***MODIFICATION REQUEST:  
Residential Development Stage 1 Phase 1  
Royal Rehabilitation Centre, Ryde  
MP10\_0189***

***Modifications to Residential Flat Building***

Director-General's  
Environmental Assessment Report  
Section 75W of the  
*Environmental Planning and Assessment Act 1979*

September 2012

Drawing Number A-PA-FP-AE1	Revision 02	Date 2012-05-10
Issued for PA	Scale 1:200@A1	Drawn RB

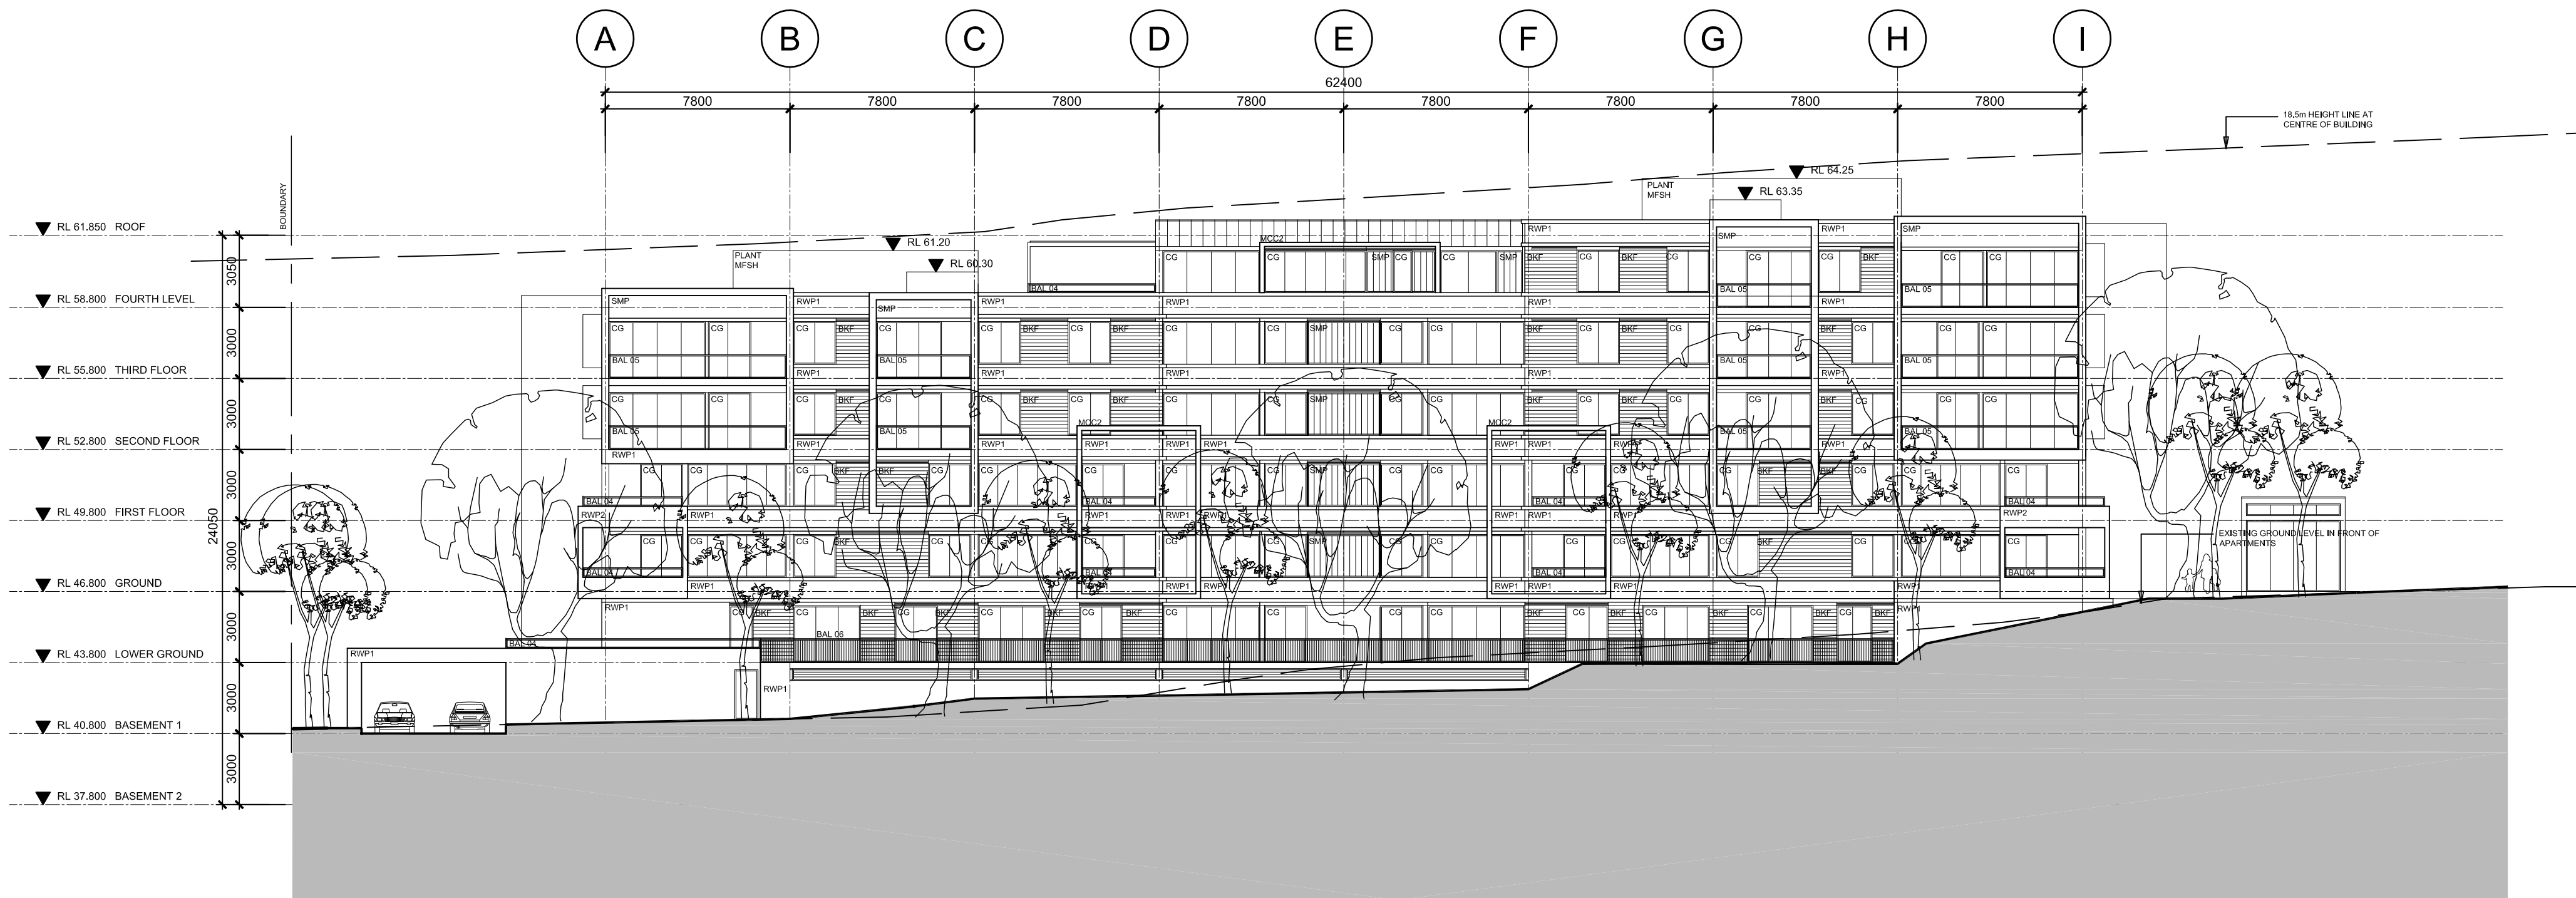
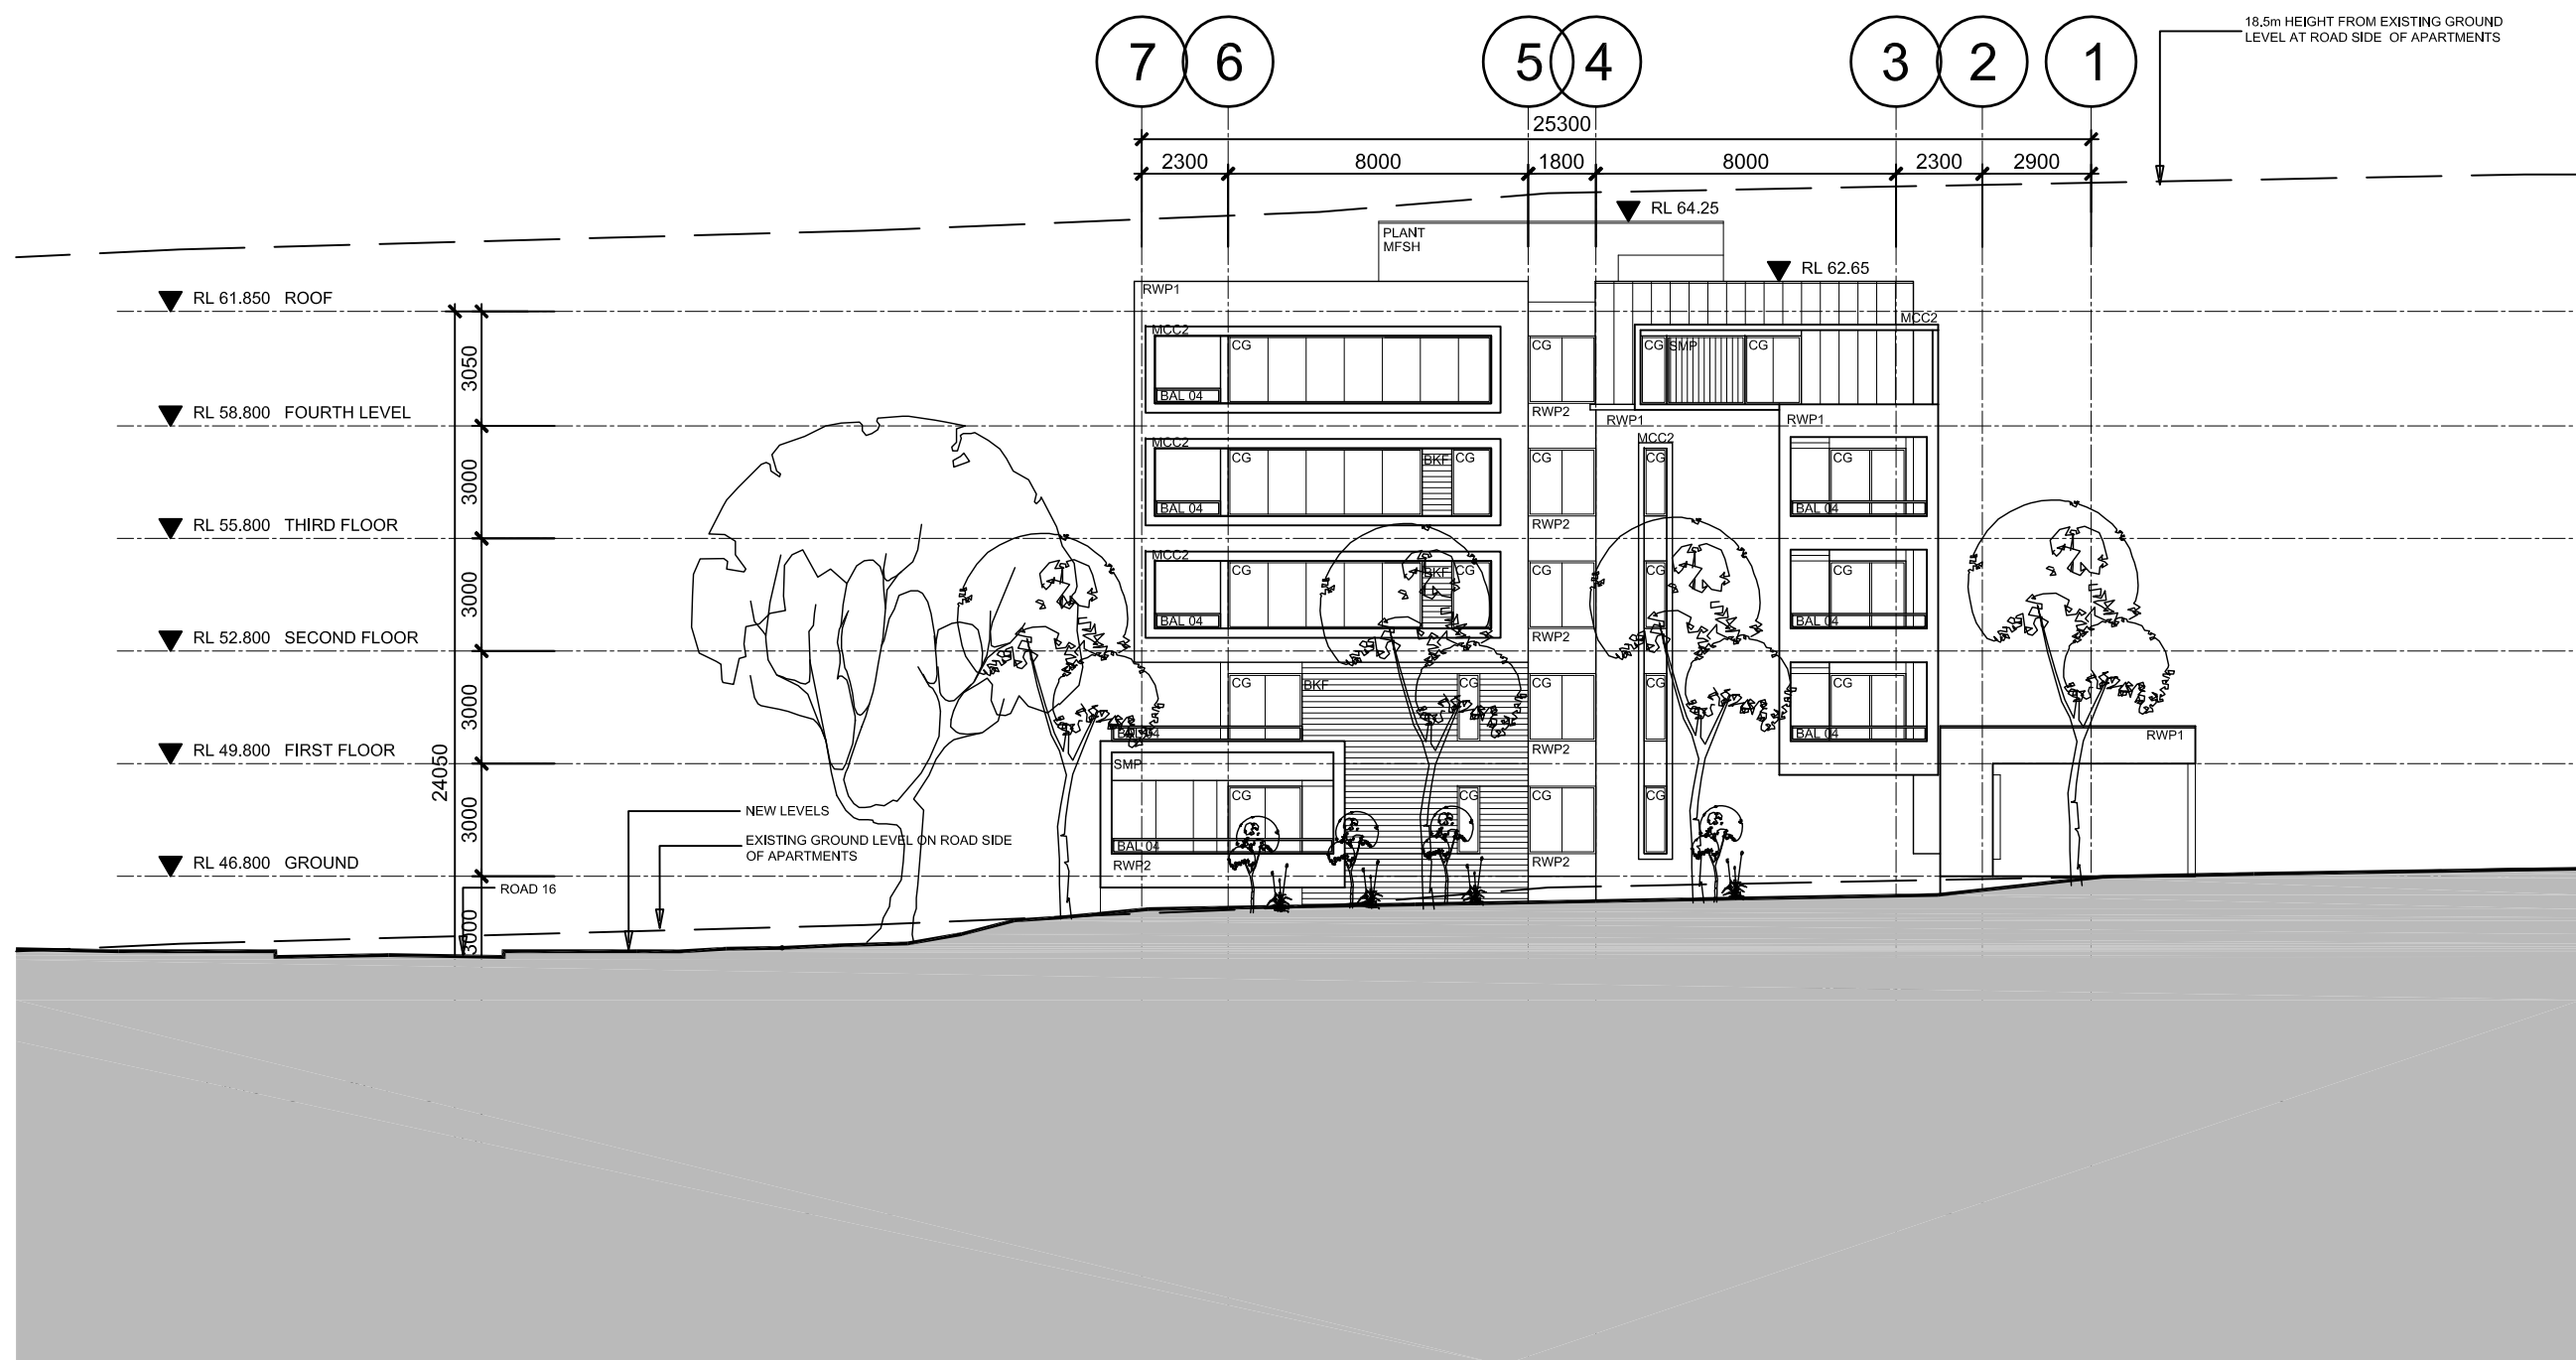
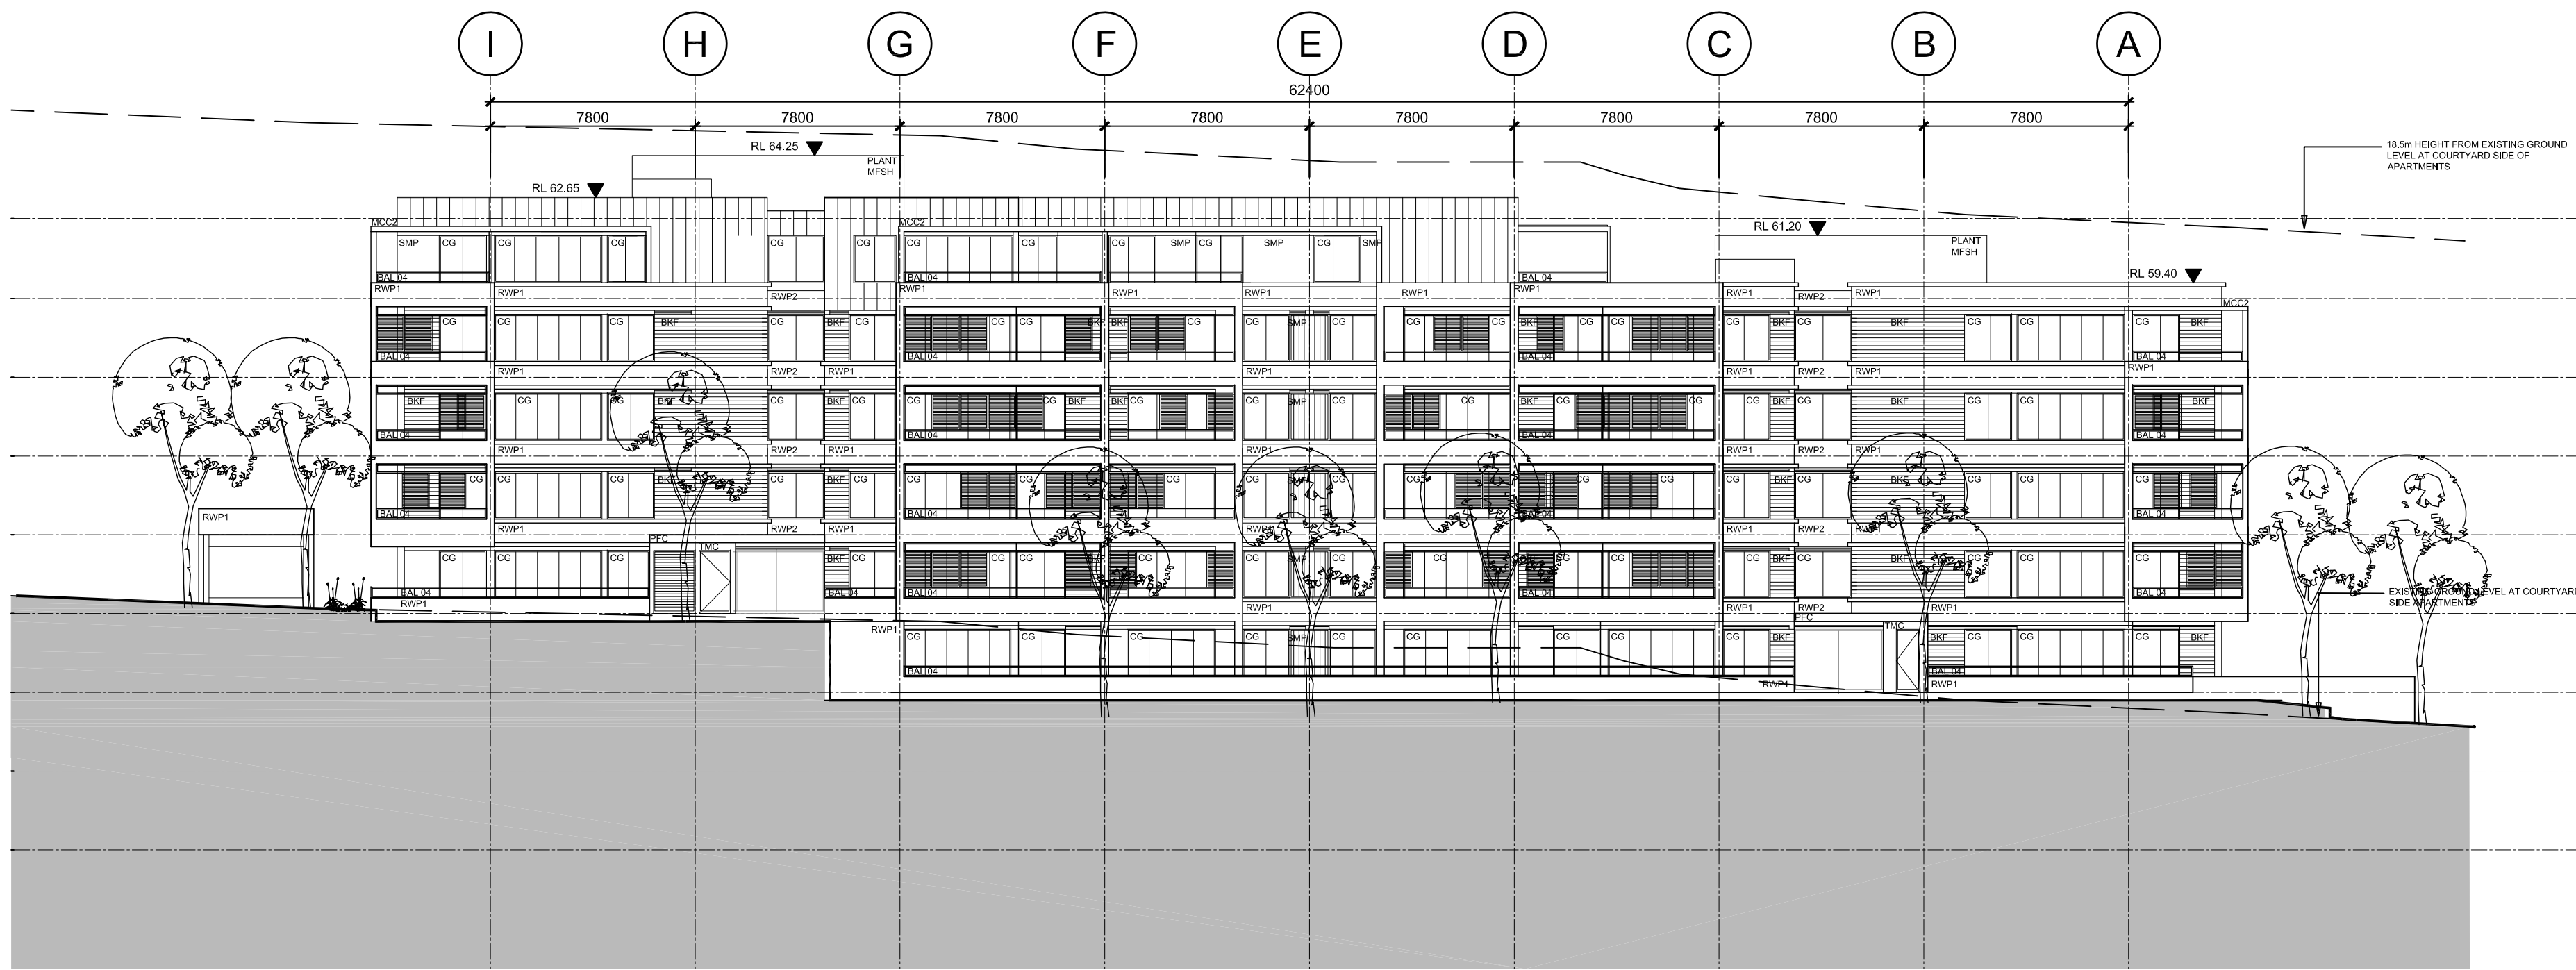
The proposed modification increases the height of the approved residential flat building. The proposal also increases the floor space and therefore the bulk at the upper levels. The resulting visual impact is demonstrated by the photomontages in **Figure 2** and **Figure 3**.

While the highest point of the modified building would only be only 0.25 metres higher than that approved, some parts of the building are increased in height by as much as 3 – 6 metres. As a result, the proposal, in particular the roof top plant, no longer fully complies with the 18.5 metre height control under the Ryde Local Environmental Plan (LEP).

Given that the proposed building will be visible from the adjoining Calvary Retirement Village, it is considered that the visual impacts of the building should be no greater than that permitted under the controls. A reduction in the height of the plant enclosures from 2.4 metres to 1.6 metres is required to ensure compliance with the LEP control. The proponent advises that it is possible to screen all plant with a 1.6 metre high enclosure and as such a condition is recommended requiring the plans to be amended so that all plant screening is within the 18.5 metre height limit.

As discussed in Section 5.1, a condition is recommended requiring a reduction in height to comply with the 18.5 metre control.
